Comments for Planning Application 24/00171/OUT

Application Number: 24/00171/OUT

Address: 24 High Street Cullompton Devon EX15 1AA

Proposal: Outline for the erection of a dwelling with some matters reserved and additional parking for No 24 High Street

Proposed Site Plan
scale 1:200

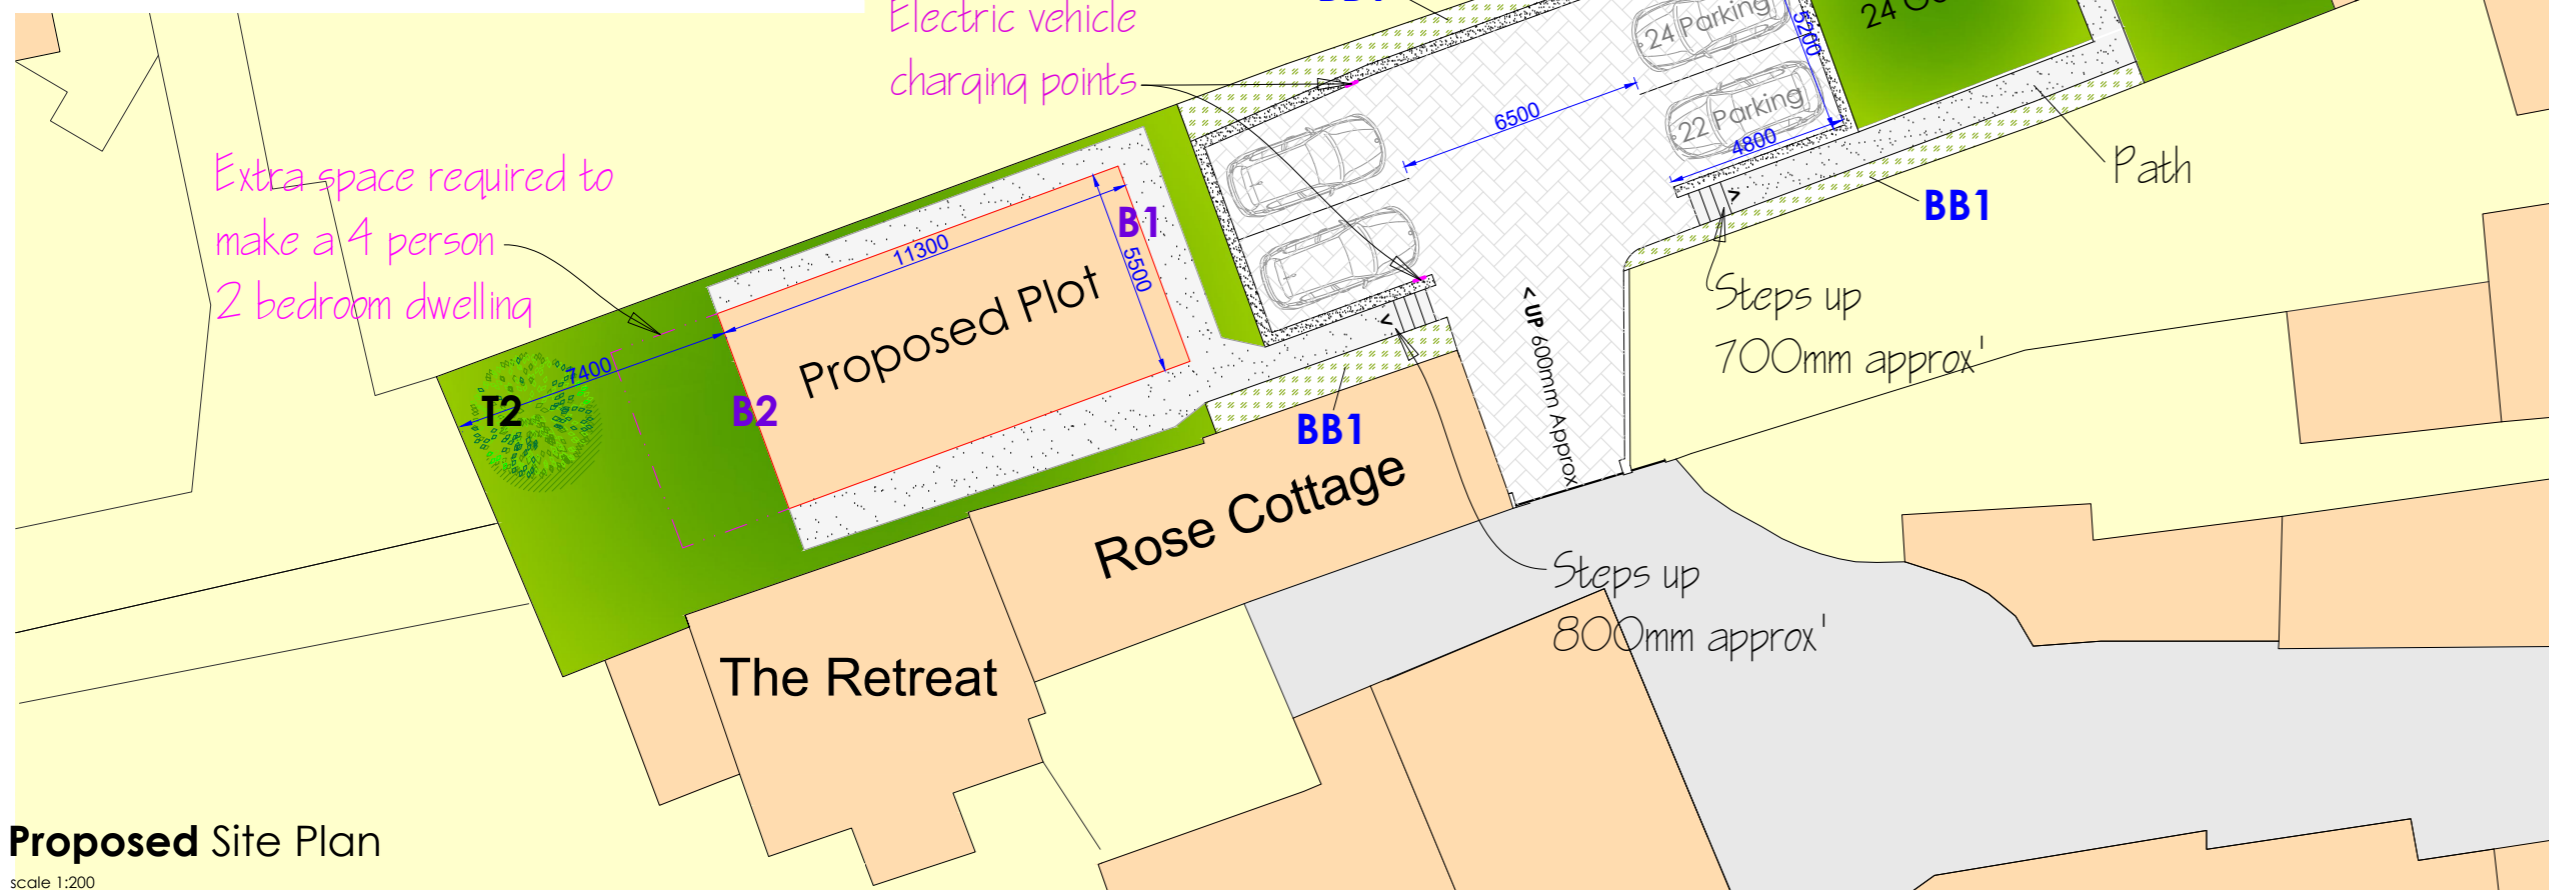
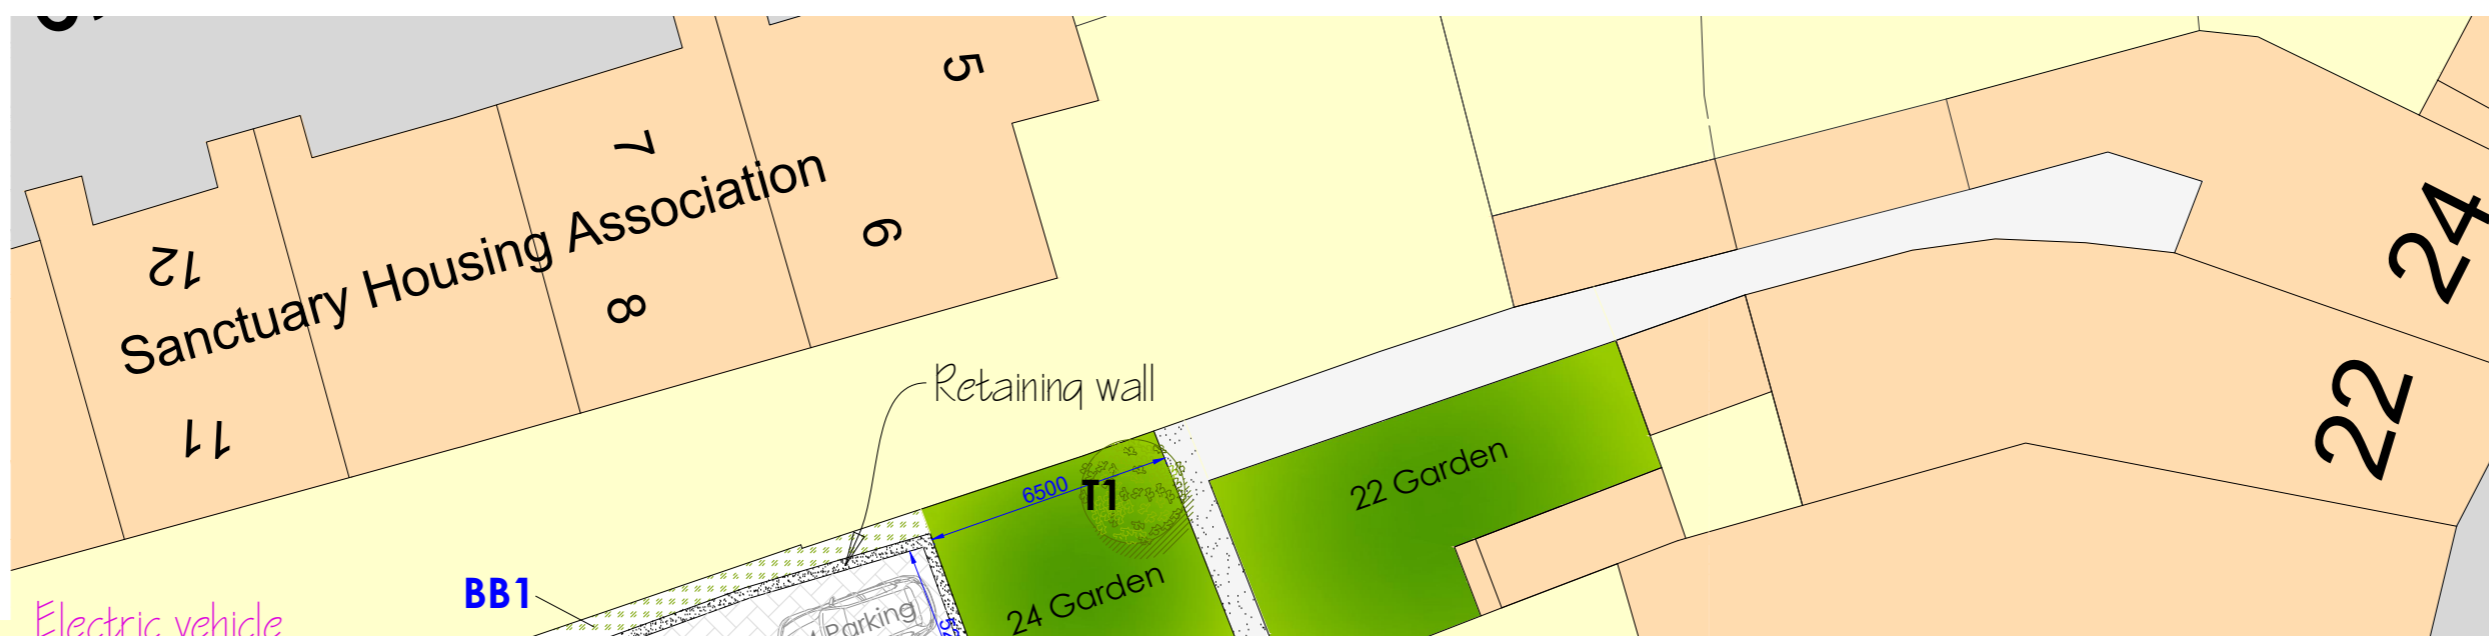
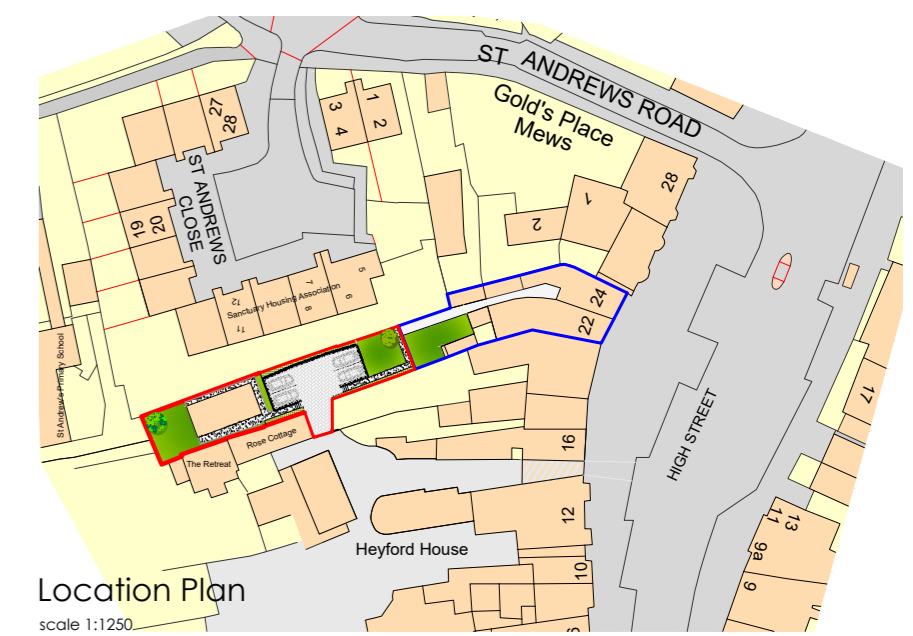
The proposed vehicle access through the tiny offset garage/store is absolutely unviable. Their plan shows the route is impeded by Gidley Coach House. The reality is far worse than illustrated. The extremely restricted turning area and angle would require multiple manoeuvres, so risking damage to both property and people. Namely my neighbours, myself, visitors and business personnel carrying out their daily routines.

Have they allowed sufficient turning radius for parking as the application site curtilage looks tight on the plan?

They are suggesting a precarious route to and from their proposed car park with blind corners and impeded manoeuvrability. Whether entering or exiting, It's just not safe!
